The Department's Comments

Figure 10: Modified 1A Signal Layout (Mamre Road / Bakers Lane)

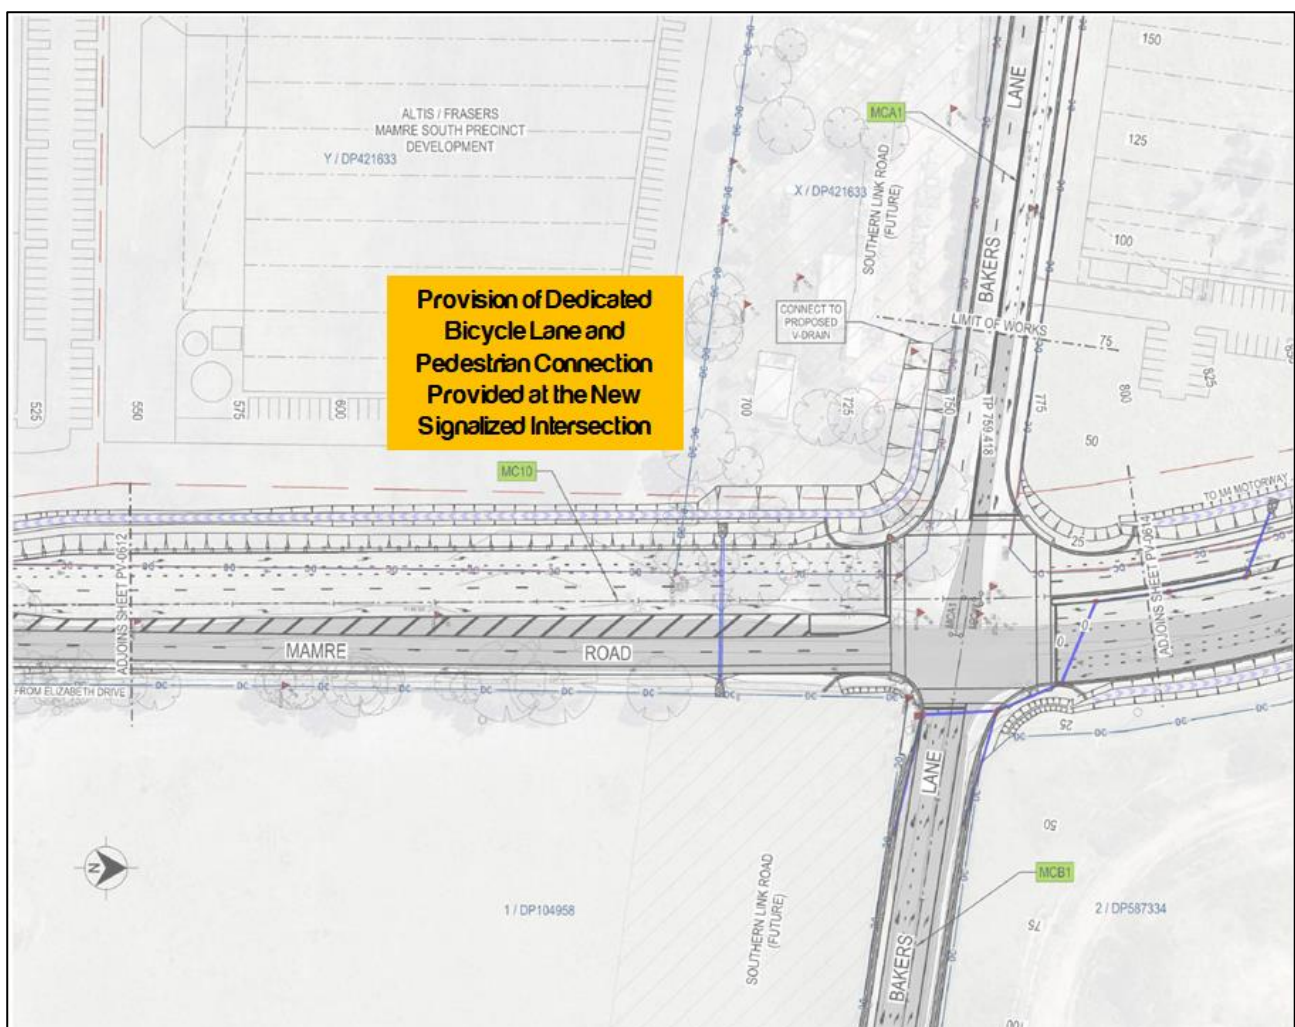
8. The Department notes several figures within the Traffic Assessment (TA) are not legible including Figures 10, 11 and 35. Please update the TA to ensure all figures are legible.

Figure 7 Receptors including in dispersion modelling

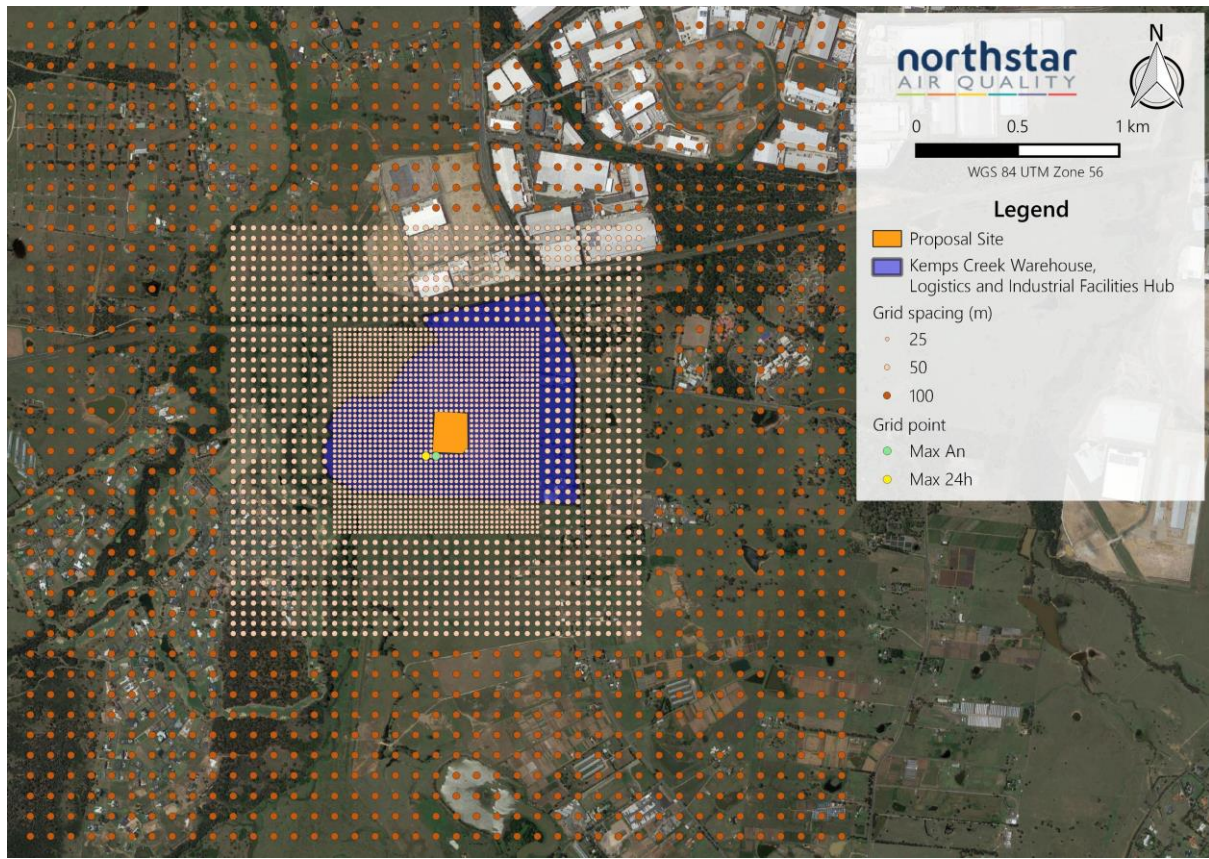
24. The Department requires the Air Quality Impact Assessment (AQIA) to be revised to include a map identifying the sensitive receptors used in the assessment. Details of the property addresses are also required.
25. The Department notes the AQIA considers cumulative air quality impacts. The Department requires the Applicant to confirm whether the Kemps Creek Data Centre (SSD-1010198) is included in the AQIA. The AQIA is to be updated as required.
26. The Department notes the AQIA recommends an Air Quality Management Plan be prepared for the proposal without the detailed analysis to support this position. The Department requests further analysis in the assessment of air quality impacts.
